Demolition of the existing garage building (B2 industrial use) and redevelopment of the site providing 9no C3 residential units - This application affects the character and appearance of River Road Conservation Area.

25 River Road Littlehampton

Thank you for your internet representation made on 27th May 2019 which has been recorded as '**an objection**' with the comments as follows:

PROPOSED DRAWINGS:
Terminus Place
Proposed & Existing Street Scenes

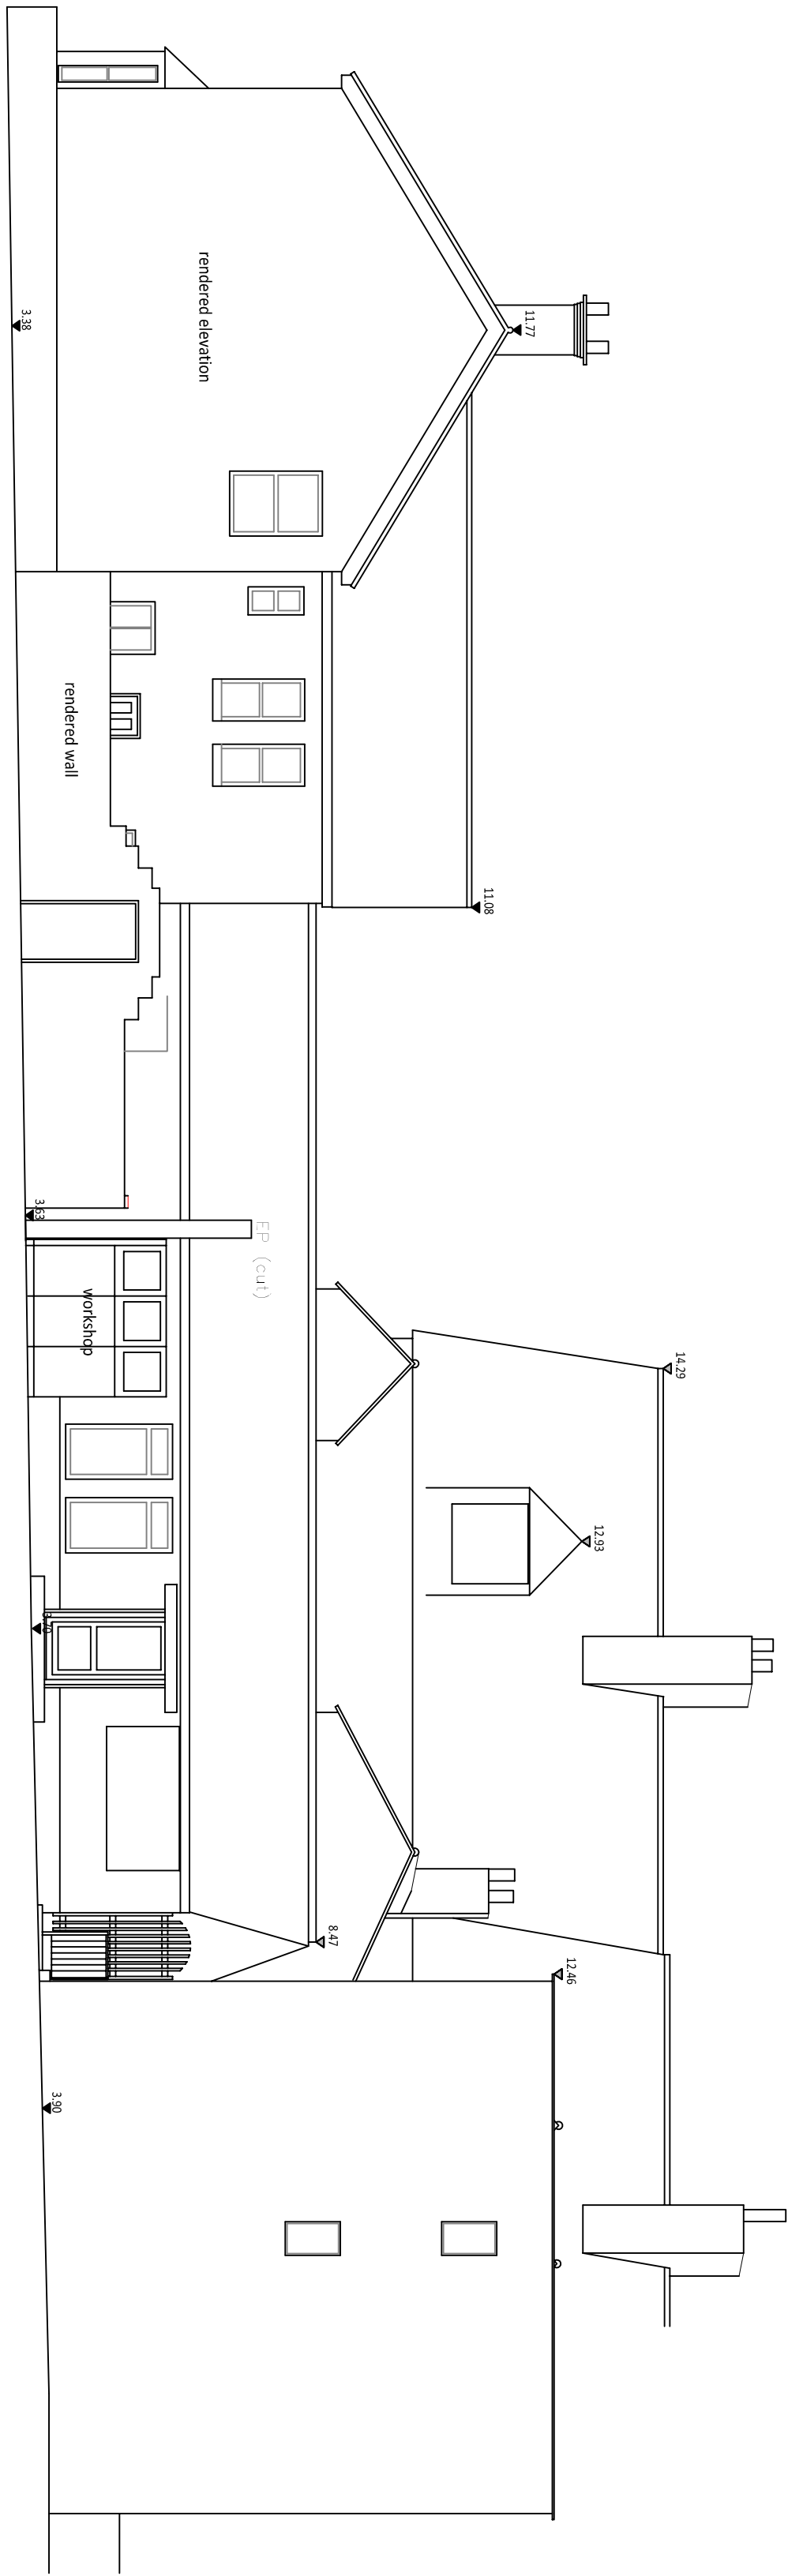
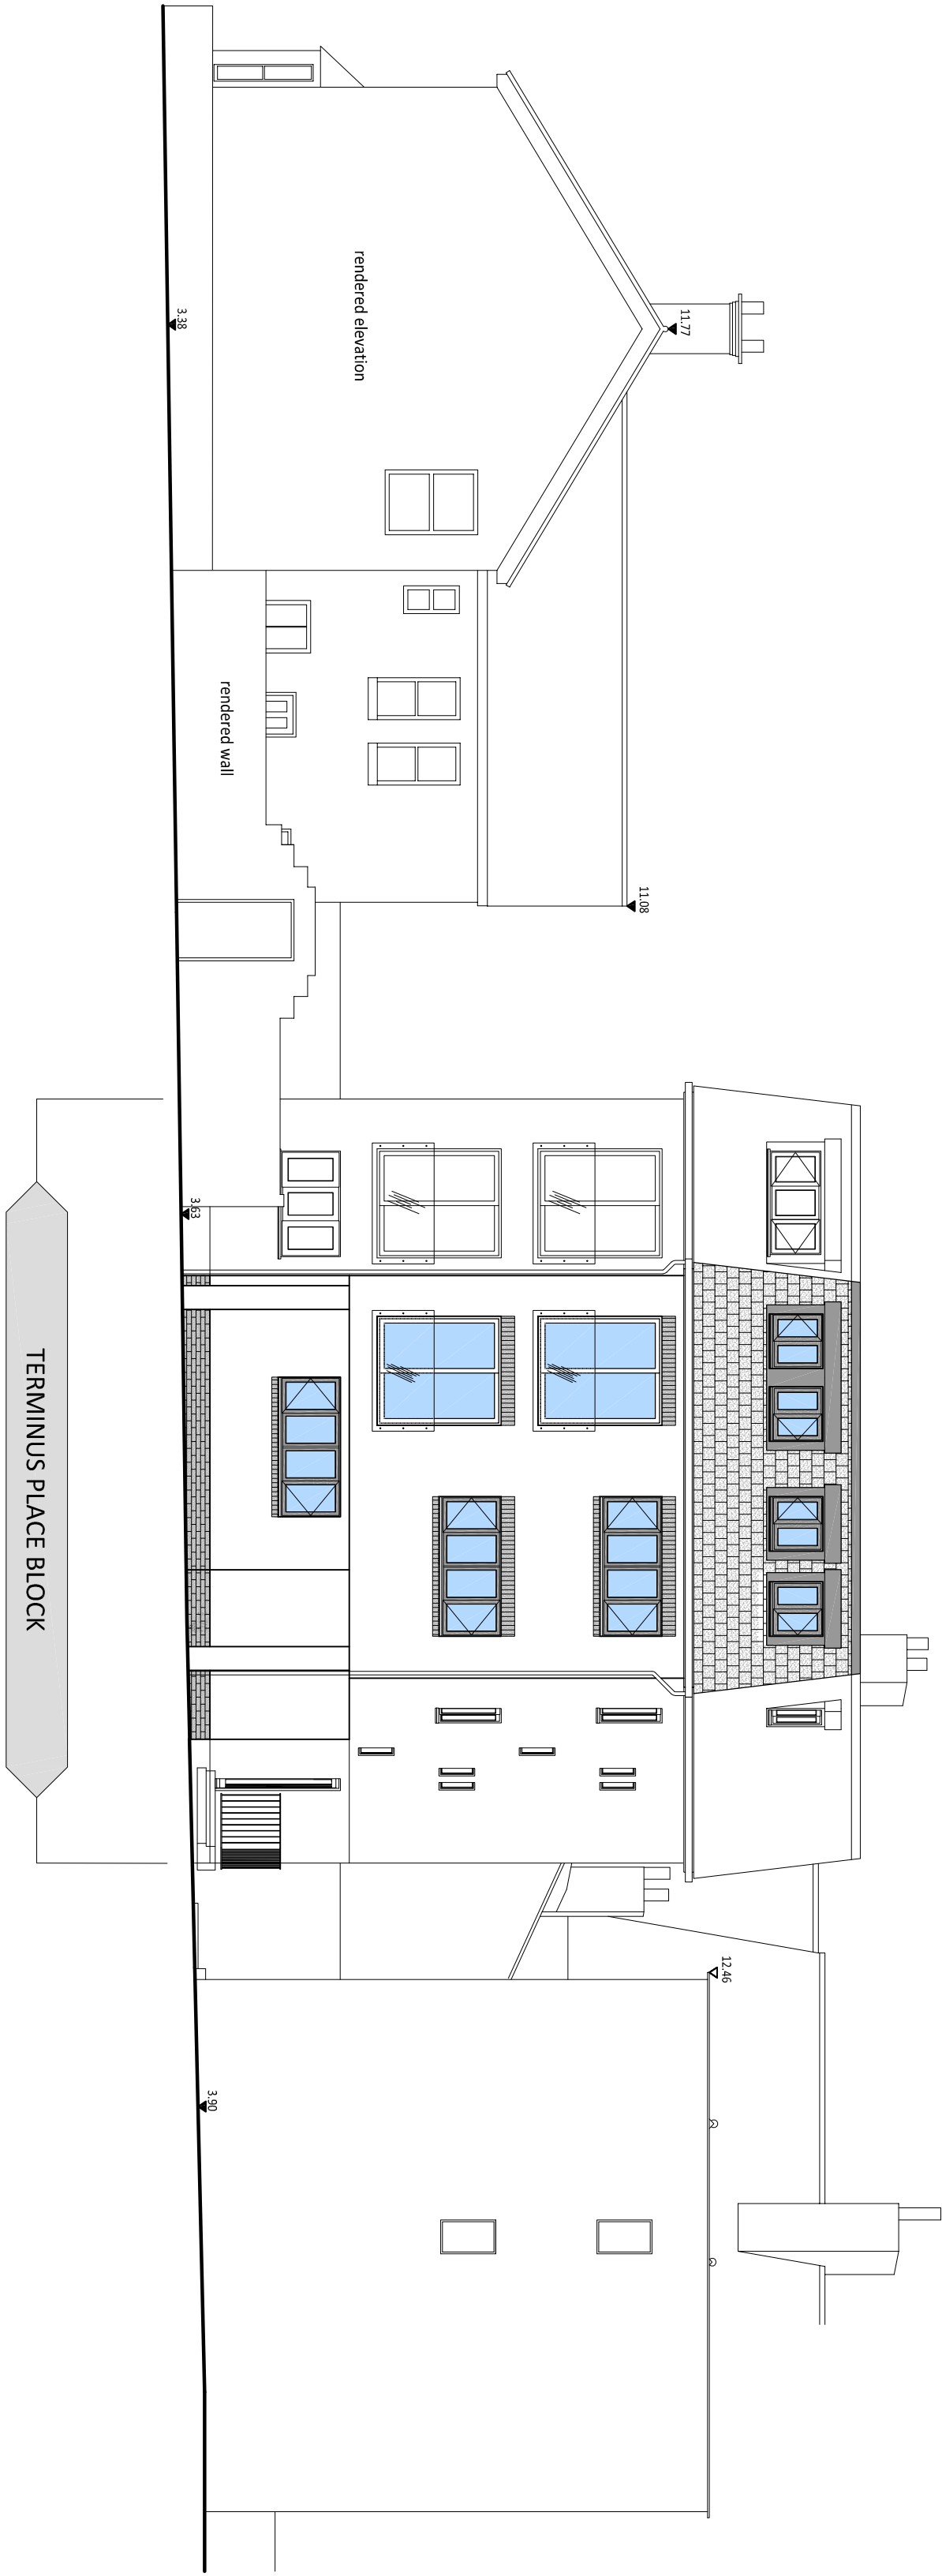
3a The height of the development is over 1 third higher than existing properties
